MEMORANDUM

SUBJECT: SF-19-004 – Homestead Filing No. 2 Sterling Ranch
Third Submittal
LSC Response Below (3-3-2020)

Engineering Division

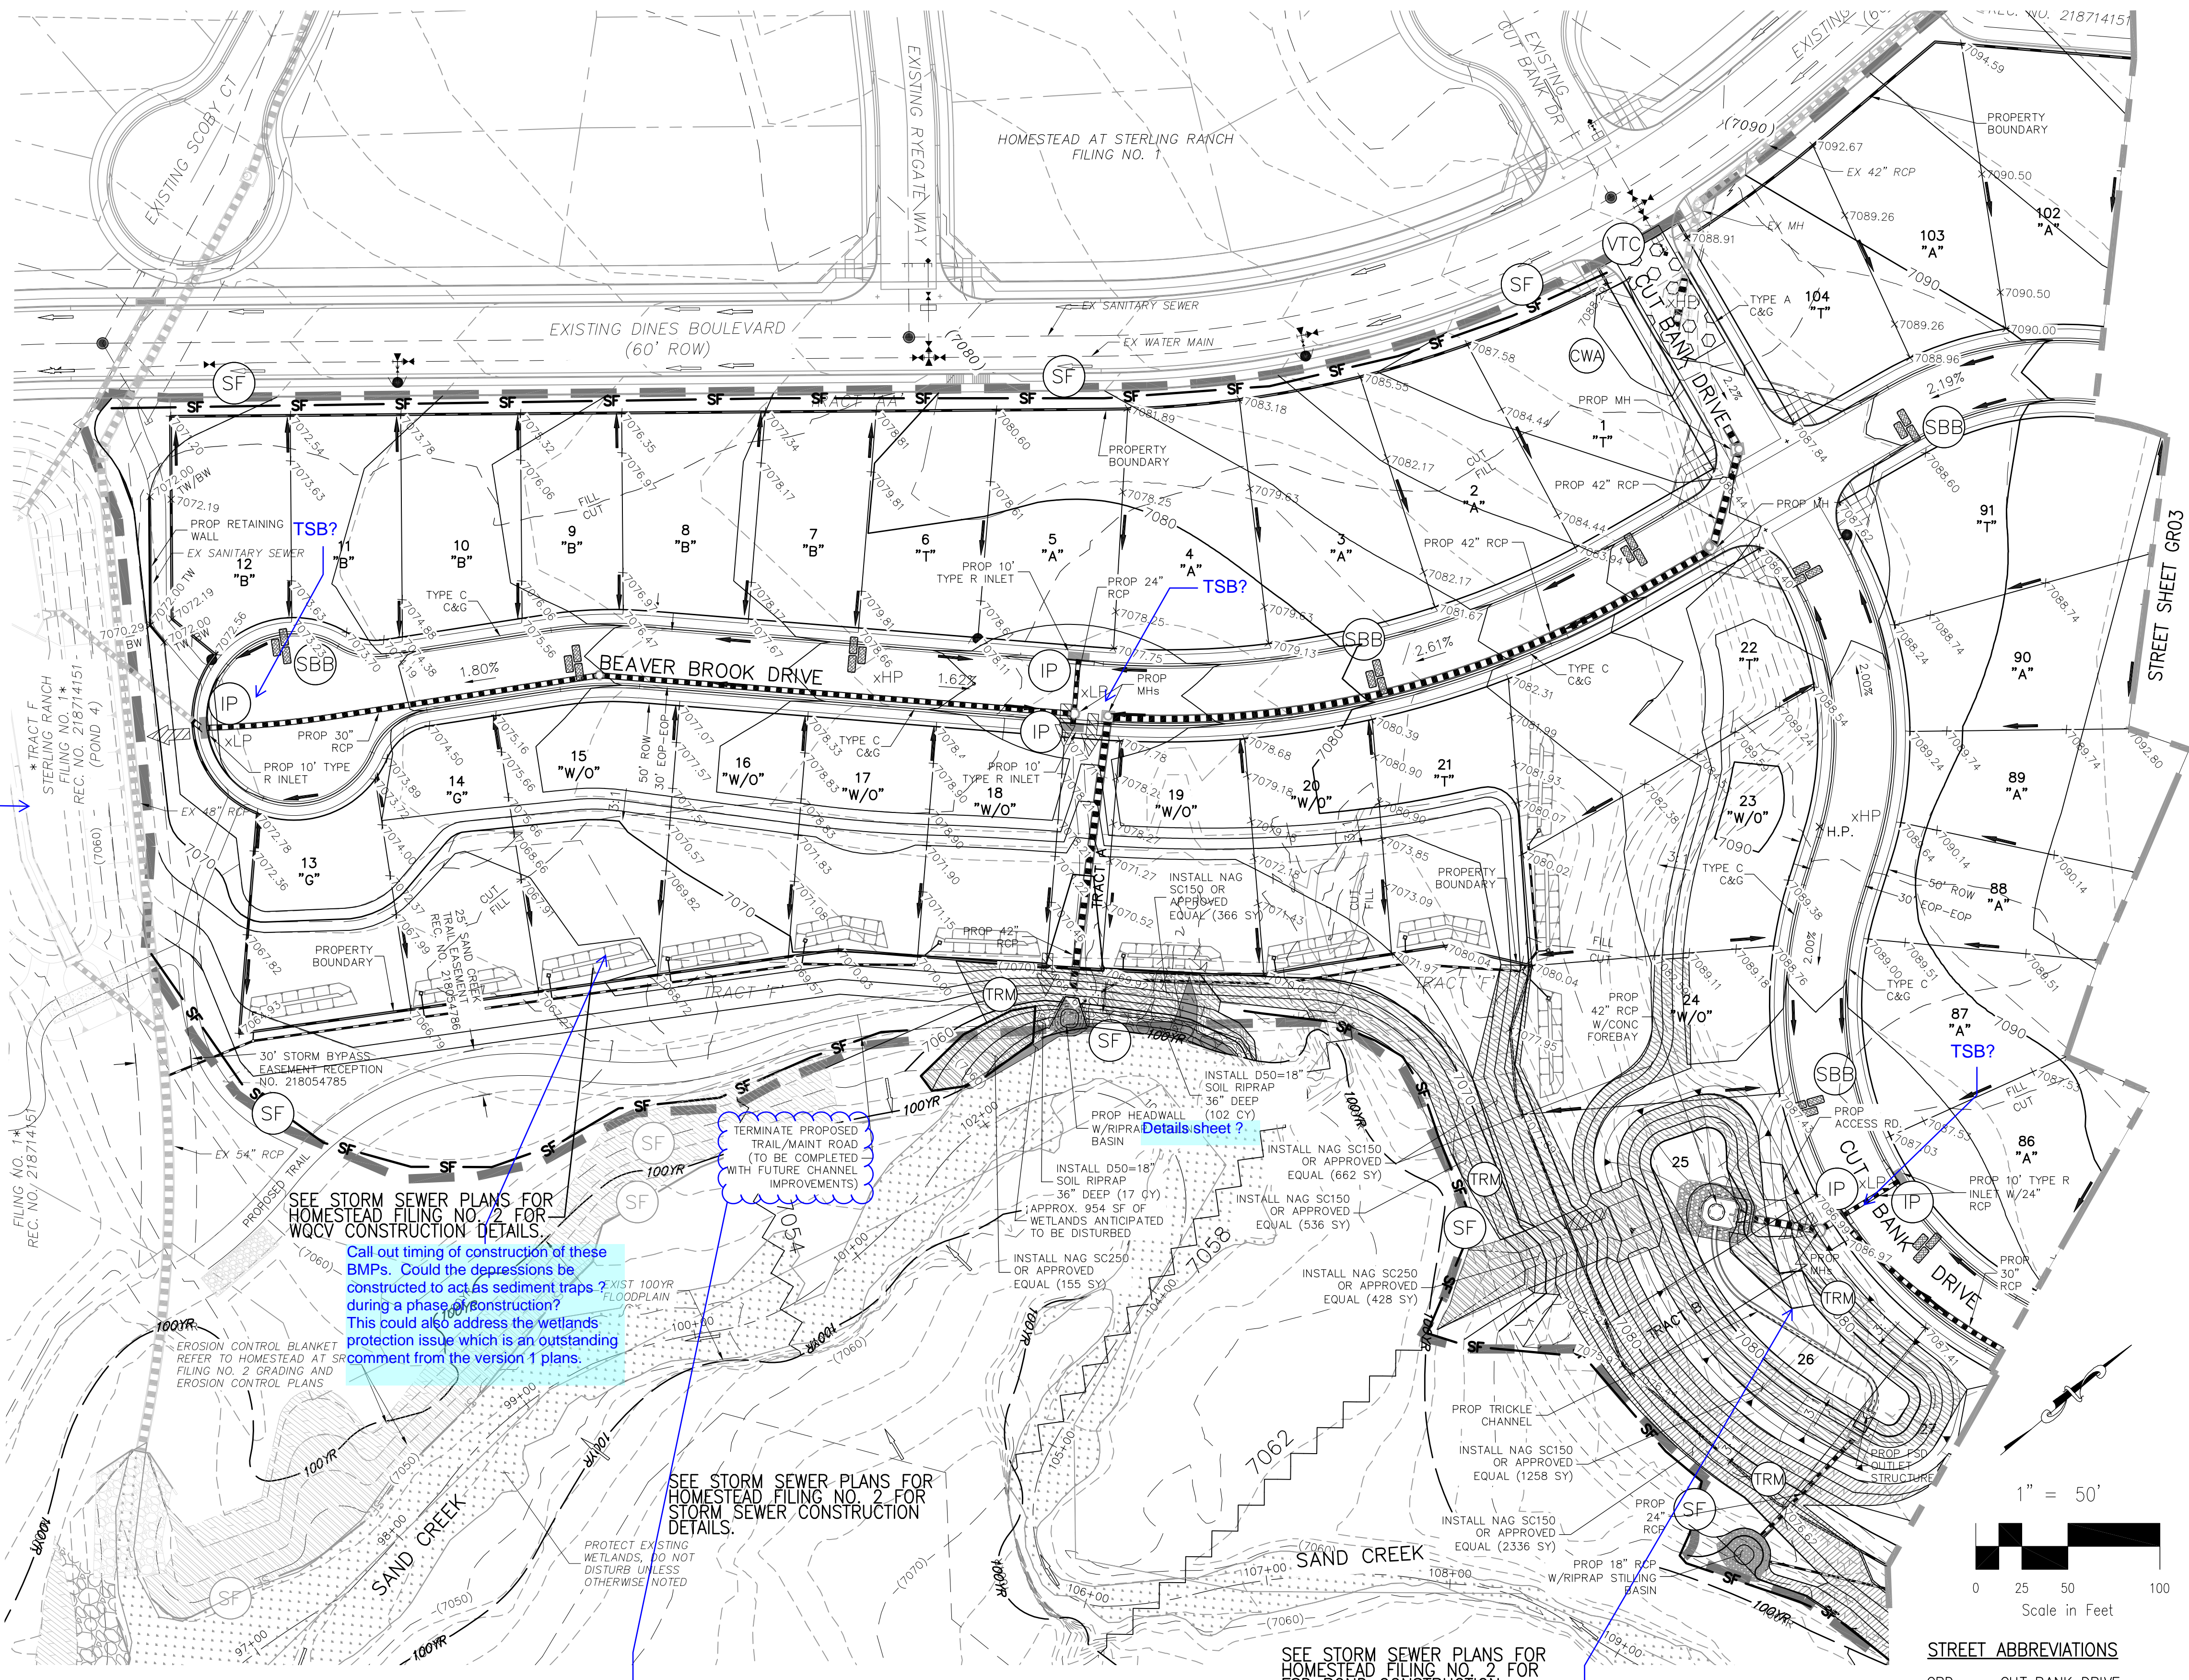
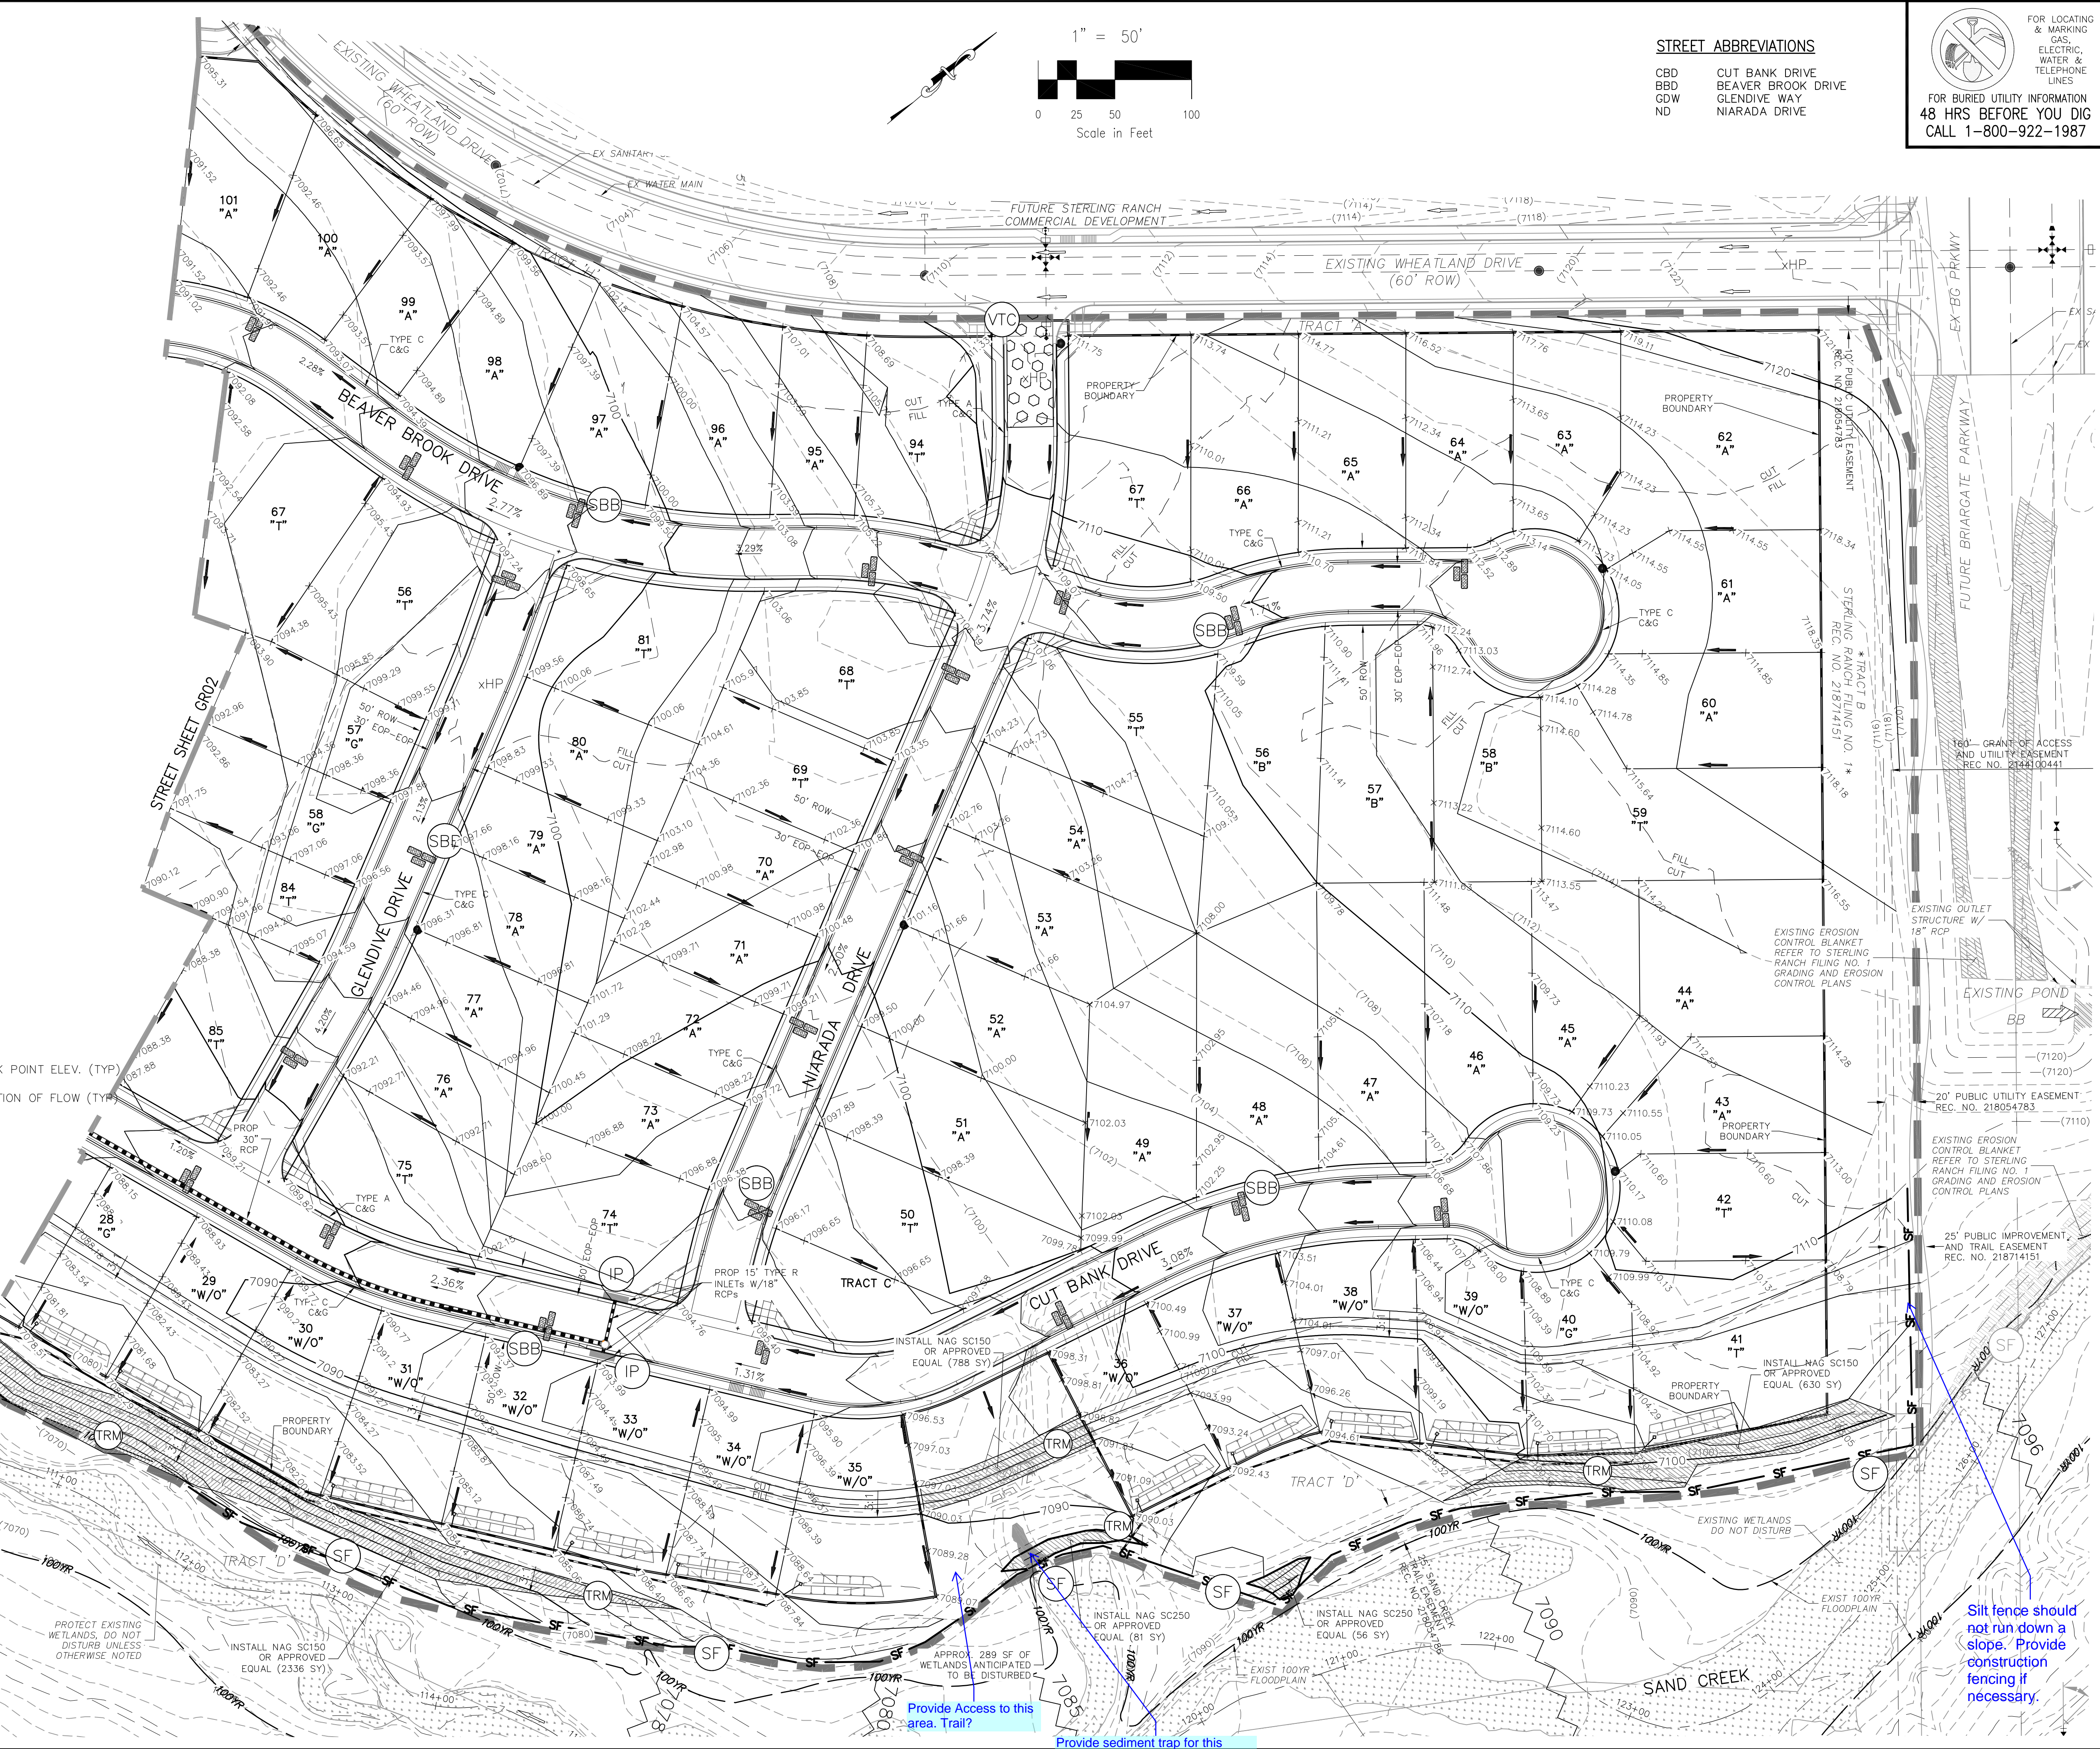
6. **Resolved.**
7. Include all necessary improvements including channel stabilization in the GEC Plan and SWMP. Address short-term and long-term stability of the channel beside this subdivision. **To be verified with revision of bank stabilization plans.**

8. Clearly show and label all maintenance access roads and the trail on the plans. **Unresolved.**
9. Add the SFBs to the legend. **Unresolved.**

PROPOSED DRAINAGE MAP

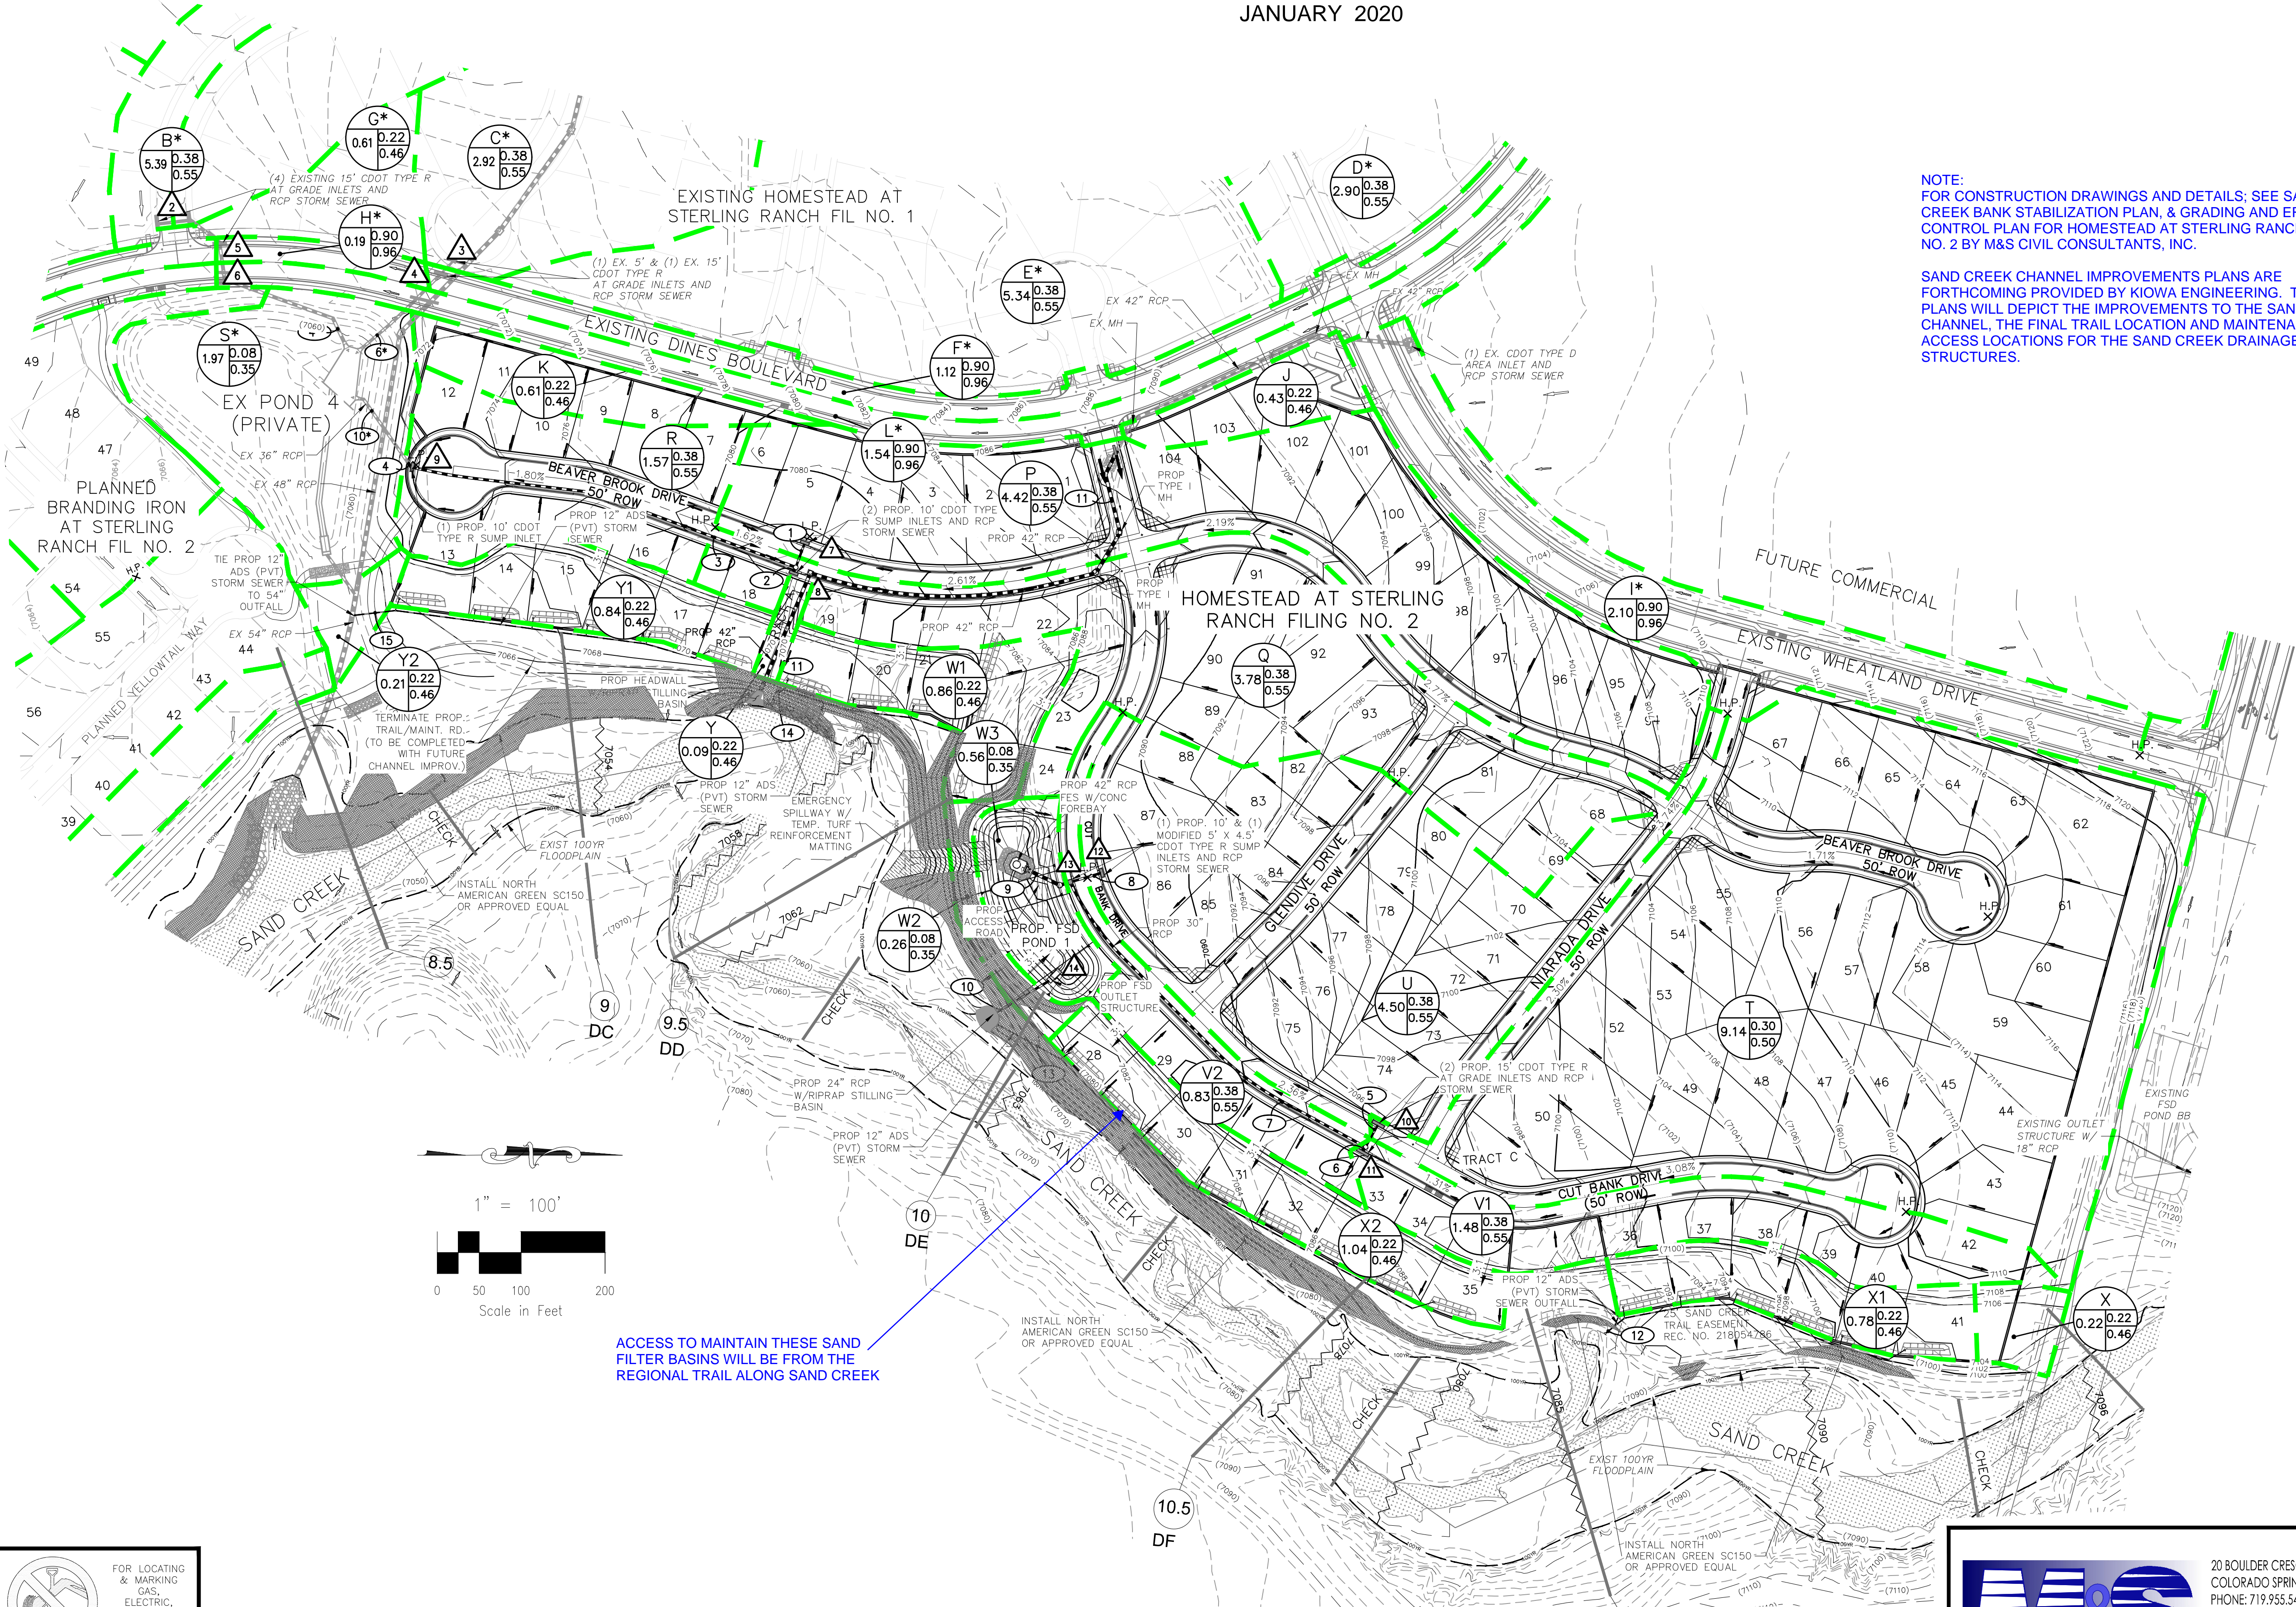
- b. Provide discussion of maintenance access and aspects of the preliminary design. **Show access roads for ponds and channels on the drainage plans.** Reference ECM 3.3.3.K. **Unresolved.**

8. See updated FDR and drainage plan redlines. **Partially resolved;**
 - a. **See remaining redlines.**
 - b. **The response that the trail will be utilized to access and maintain SFB’s requires the access road/trail to be constructed so that it can access the drainage facilities on the plans. Clearly show and label the complete access road/trail on the plans.**
